App No: BR/201/20/PL
Address: 29 Highcroft Crescent Bognor Regis PO22 8DH
Proposal: Re-establishment of dwelling to form former pair of semi-detached bungalows (resubmission following BR/139/20/PL).

Liz Annalls
Environment Officer
Environmental Protection
Chichester District Council

block plan

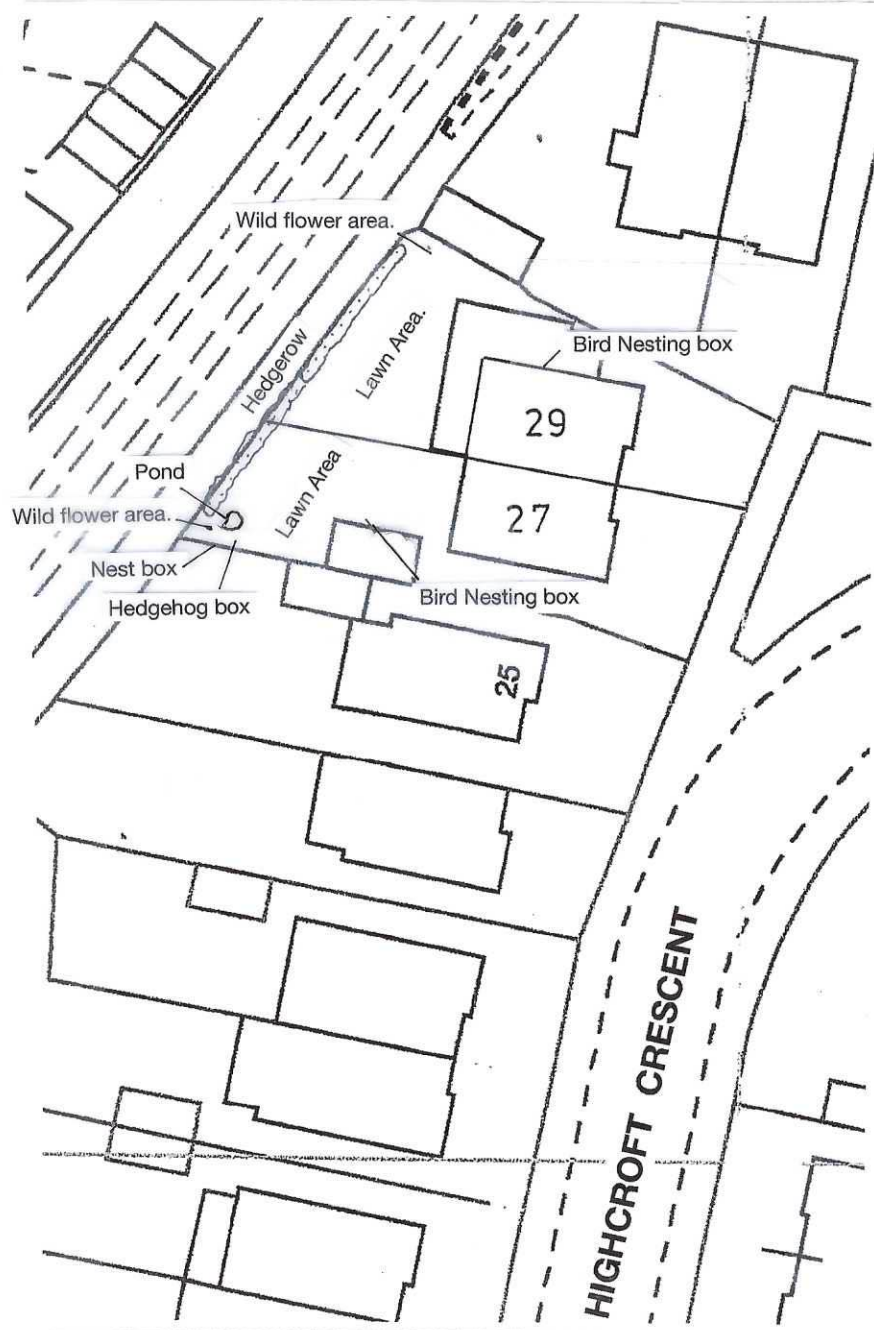
We require that a bat box is installed on the buildings onsite facing south/south westerly positioned 3-5m above ground.

We would like a bird box to be installed on the building and / or tree within the garden of the property.
